DRB Project Number: 2023-008778  
200 Tramway

SUBJECT: Sketch

### **Application For: PS-2023-00108-SKETCH PLAT (DFT)**

Project: Tract J-1-A & J-1-B, Four Hills  
Village Shopping Center &  
Apartment Complex Agenda Item No: 5

**Site Sketch for
Tract J-1-A and J-1-B, Four
Hills Village Shopping Center
and Apartment Complex
Being Comprised of
Tract J-1, Four Hills Village Shopping
Center and Apartment Complex
City of Albuquerque, Bernalillo County, New Mexico
April 2023**

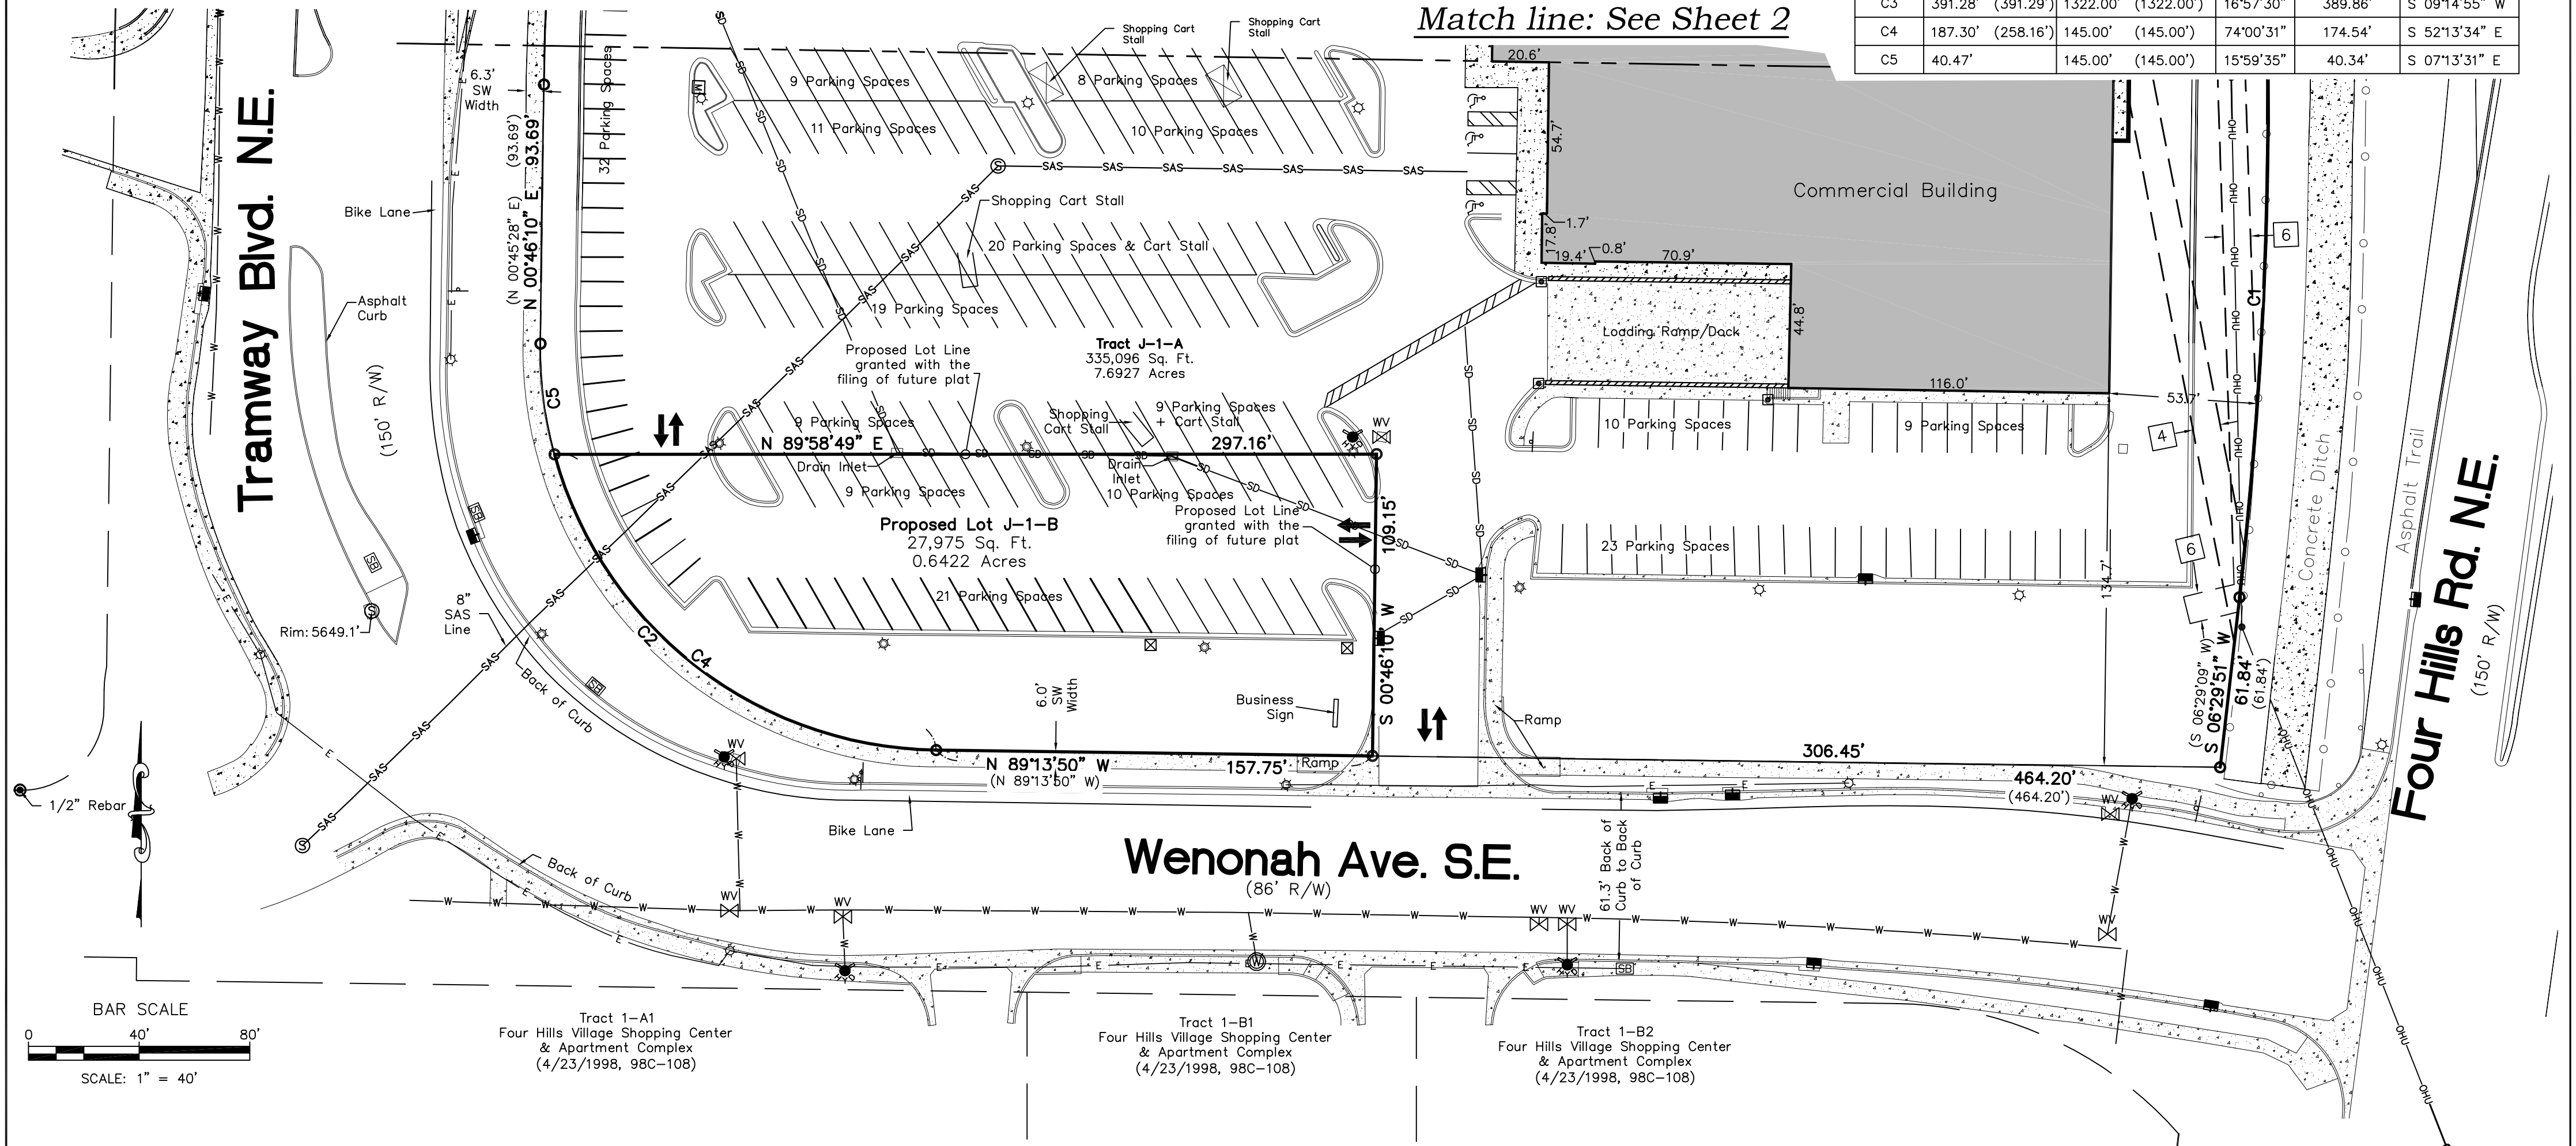
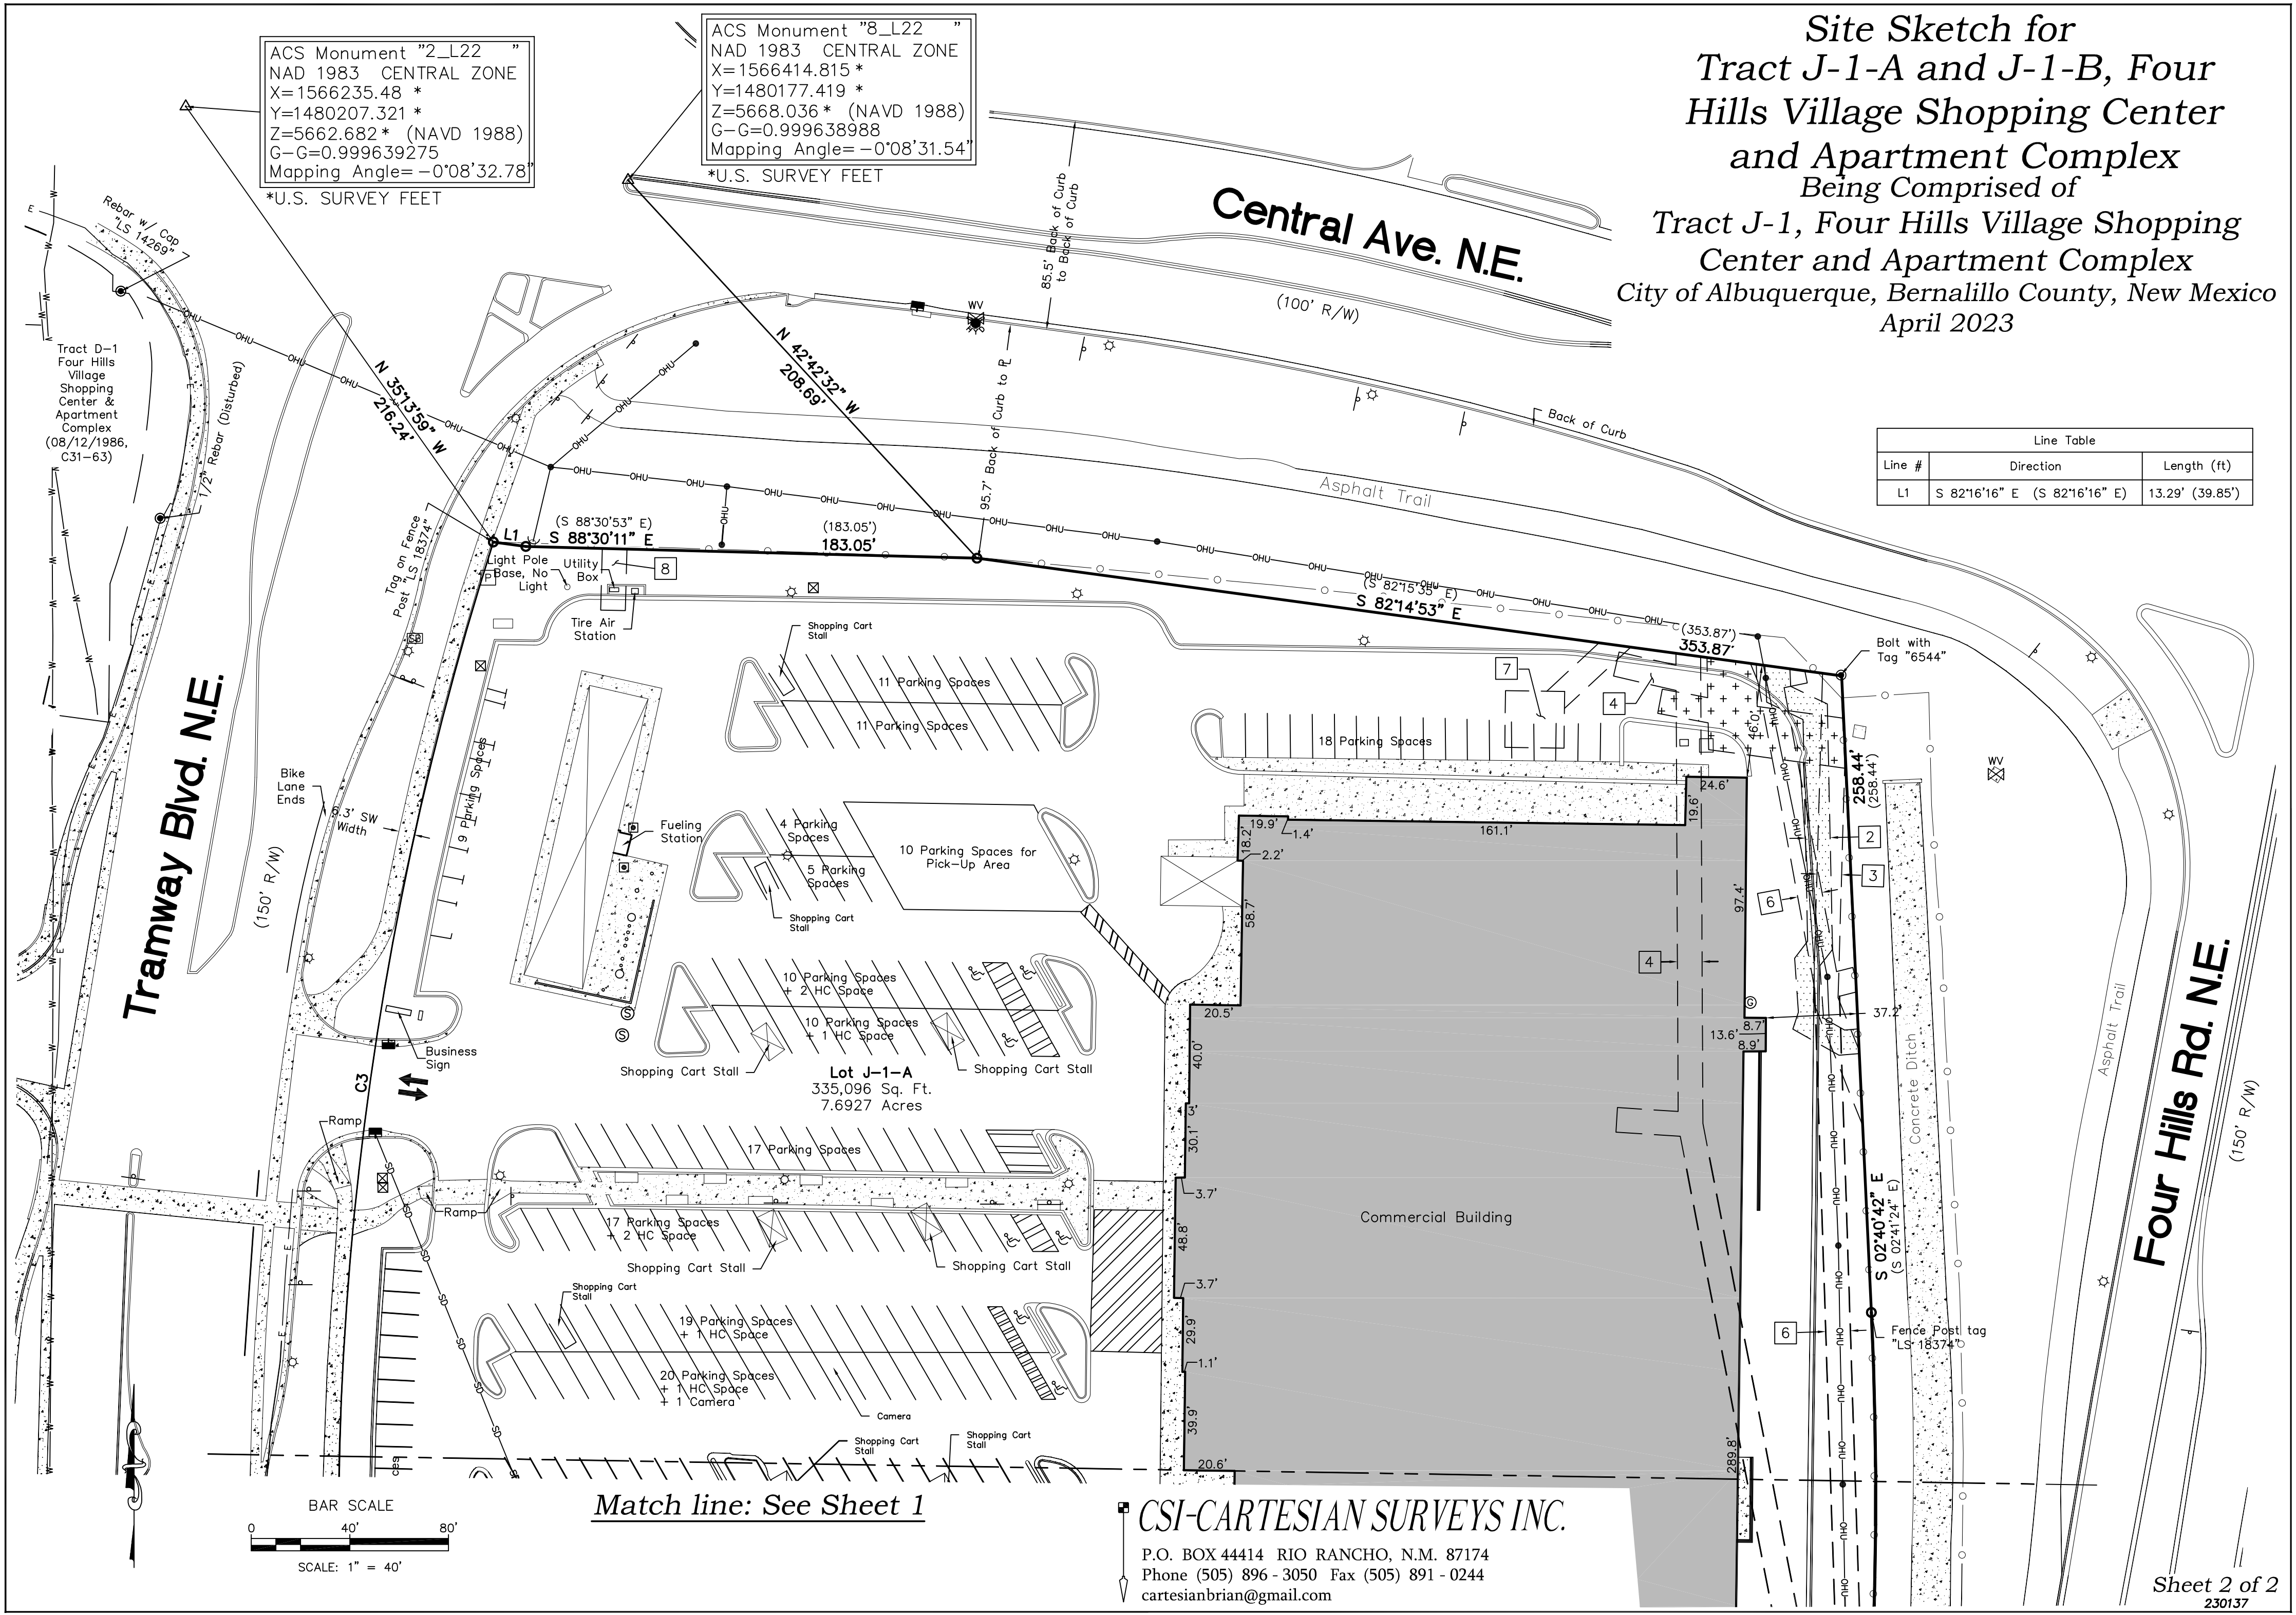
1. Please provide a cross access easement between J-1-A and J-1-B.
2. Each proposed lot must have adequate parking for its proposed use. Also, parking stalls cannot be divided by lot lines, as existing parking along the west edge is showing a split in on space.
3. For future development Transportation will require an approved TCL and an approved Traffic Study, as the proposed Starbucks requires a study.

- Add a Cross Lot Drainage Easement note specifying the beneficiary and maintenance agreement.
- Comment – Prior to submitting for Building Permit, a licensed New Mexico civil engineer will need to submit a Grading & Drainage Plan to Hydrology for review & approval if one of these conditions is met. (500 cy of grading, 1,000 sf of proposed building, or 10,000 sf of proposed paving).

- Confirm required off-street parking is met for uses on each of the created lots. If parking will be shared across any lots, then a signed and recorded shared parking agreement is required with the plat submittal. Confirm that no parking space is bisected by a lot line.

PROJECT TITLE: STARBUCKS - TRAMWAY
 200 TRAMWAY BLD. NE ALBUQUERQUE, NEW MEXICO 87123
 PROJECT MANAGER: DEVIN NGUYEN
 DRAWN BY: DTM
 SP-TRAMWAY
 SHEET TITLE: OVERALL SITE PLAN

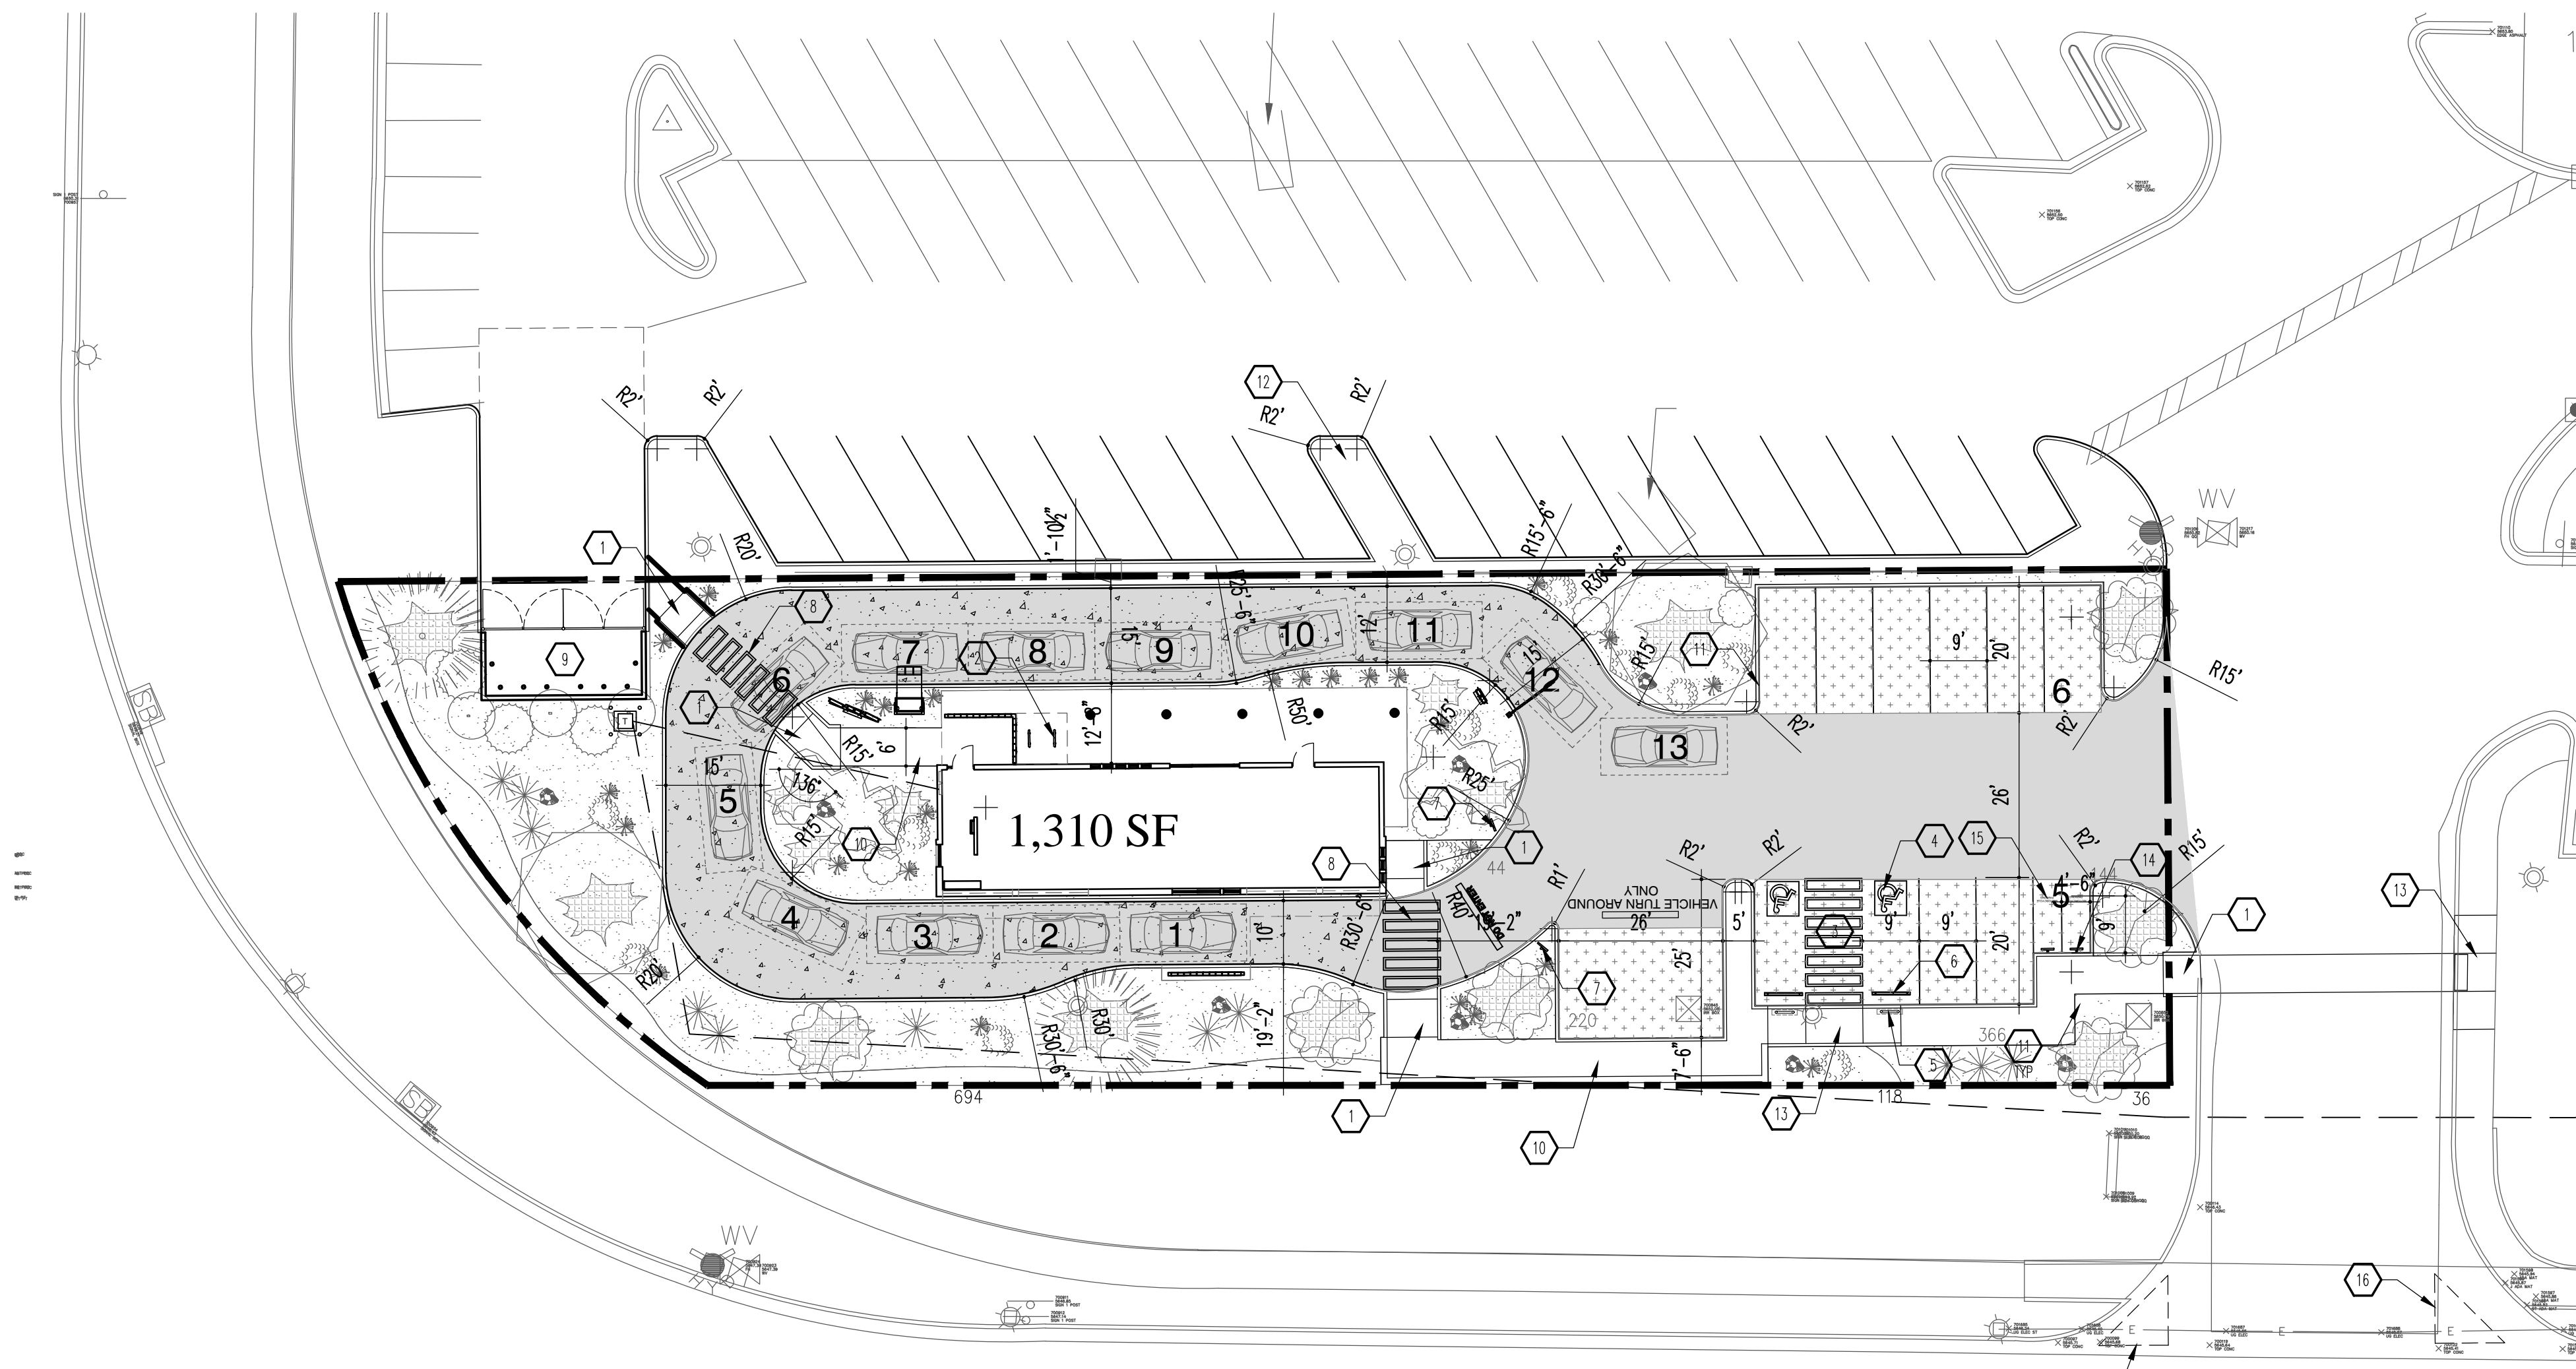
- Confirm if the current landscaping for Smith's Grocery is being reduced or relocated. Separately, demonstrate how landscaping for new development will be meeting standards.

- Clarify how circulation and access is being affected for the site, with the new use and development adding to the existing Grocery and Fueling Station.

**Provide calculation detail and any shared parking agreement information.**
